MECKLENBURG COUNTY
Park and Recreation Department

MEMORANDUM

RE: Rezoning Petition #2024-006
PID# 13314101

SHEET NUMBER  
**RZ-1**

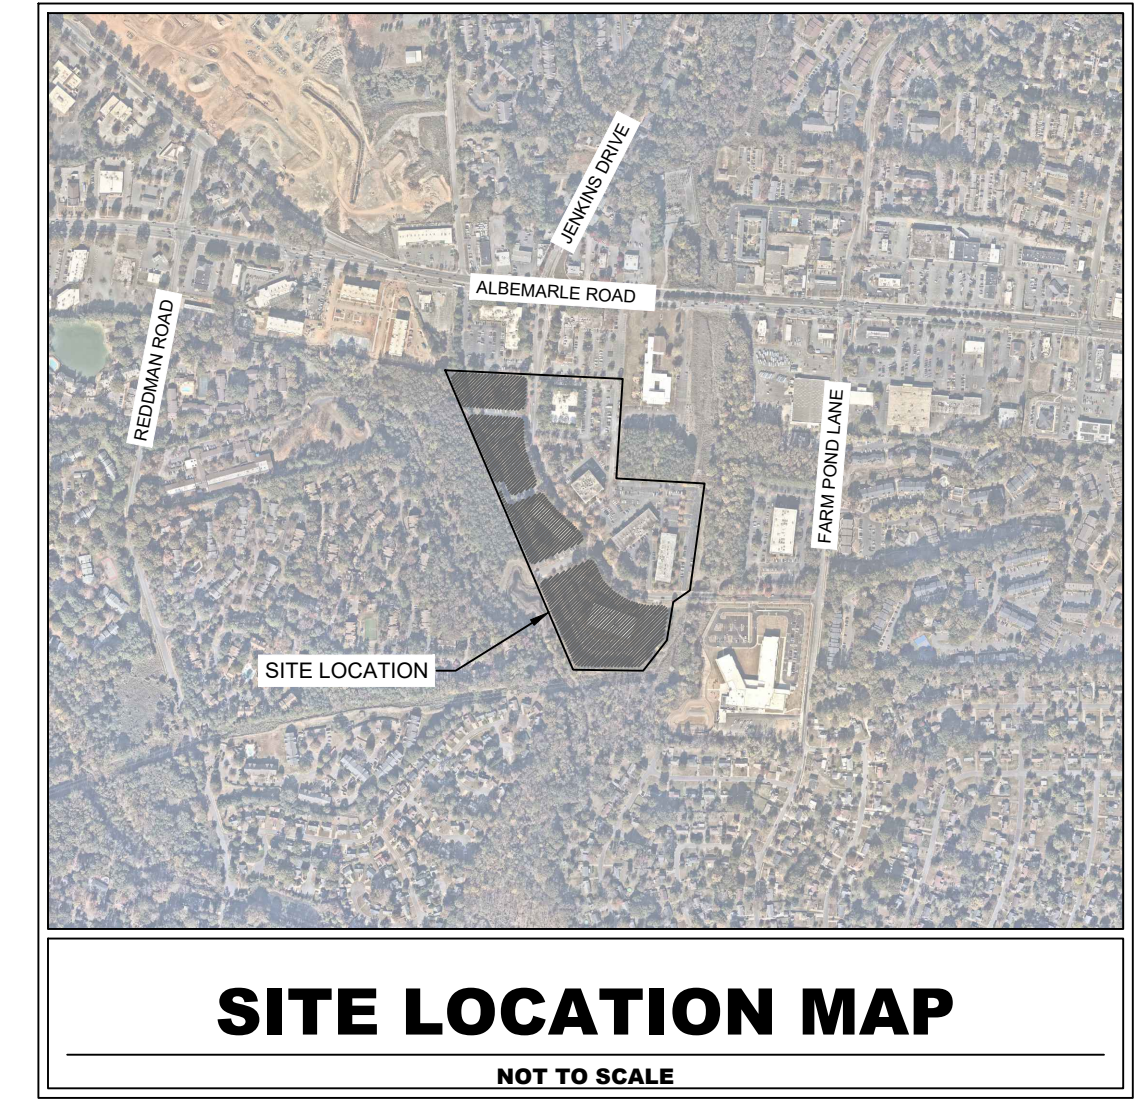
Please provide pedestrian and bicycle accommodations along the frontage of Executive Center Drive to connect to the funded Campbell Creek Greenway Trail project.

MCPR also requests a minimum of 1.25 acres to be dedicated and conveyed to Mecklenburg County for a future neighborhood park. This requested park land shall be adjacent to a public right-of-way for access and is conducive for the development of the typical amenities found in a neighborhood park and cannot include tree save parcels or storm water BMP's. Parkland shall be dedicated and conveyed by the first CO.
